Our Ref: BR/276/20/DOC

**Approval of details reserved by condition imposed under ref BR/32/16/PL relating to Condition No 3 - new boundary treatments, 6 - pedestrian visibility splays and 7 - covered & secure cycle parking.**

**3 Glencathara Road Bognor Regis PO21 2SF**

PROJECT NUMBER	3 GLE-18	DRAWING NO	A101 REVC
DATE	5th January 2021		
DRAWN BY	June Grinstead		
CHECKED BY		SCALE	1:100 / A3

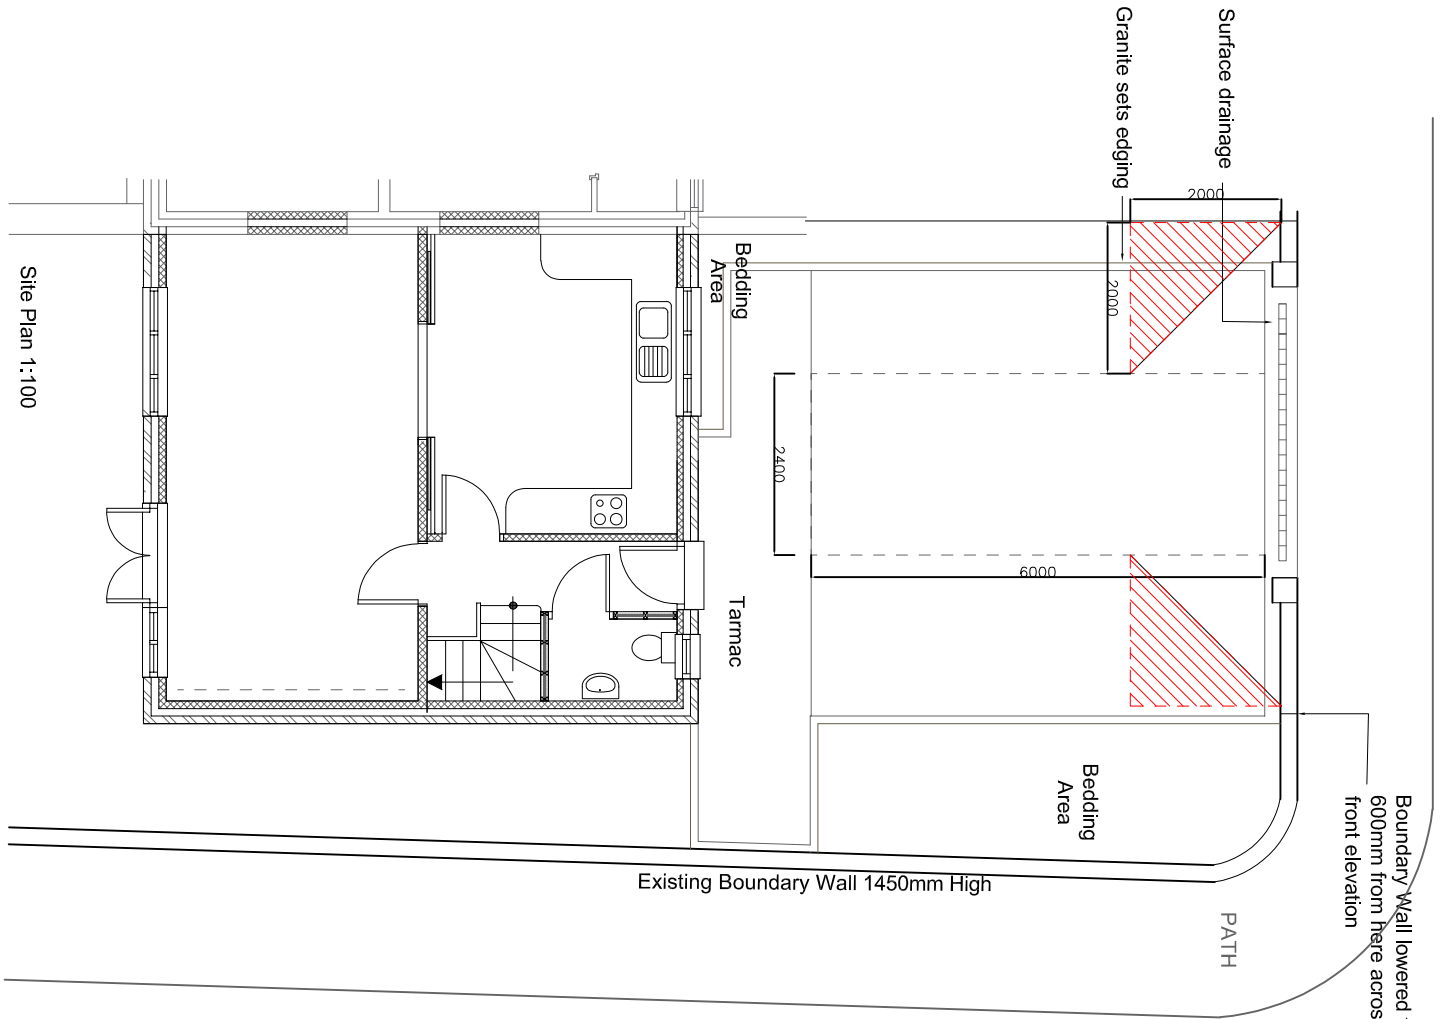
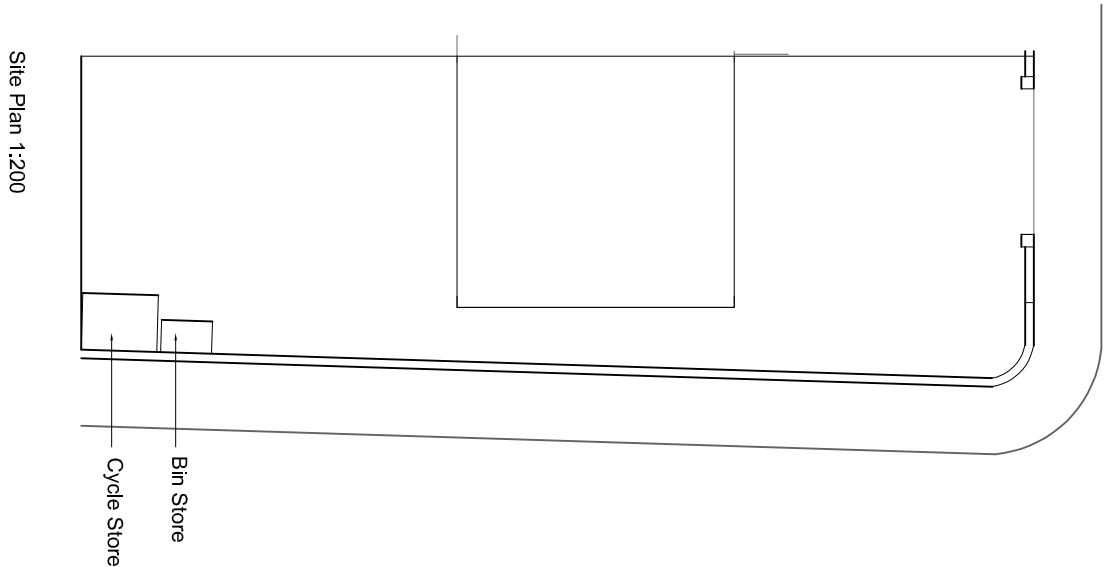
The details submitted on Drawing A101 rev C, dated 06/01/2021, demonstrate that the required visibility splays can be achieved in accordance with WSCC standards. WSCC Highways therefore are satisfied that this condition can be discharged.

The condition is therefore fully discharged insofar as the submission of details relates and on the understanding that the visibility splays will be implemented in accordance with the submitted drawings and permanently retained thereafter.
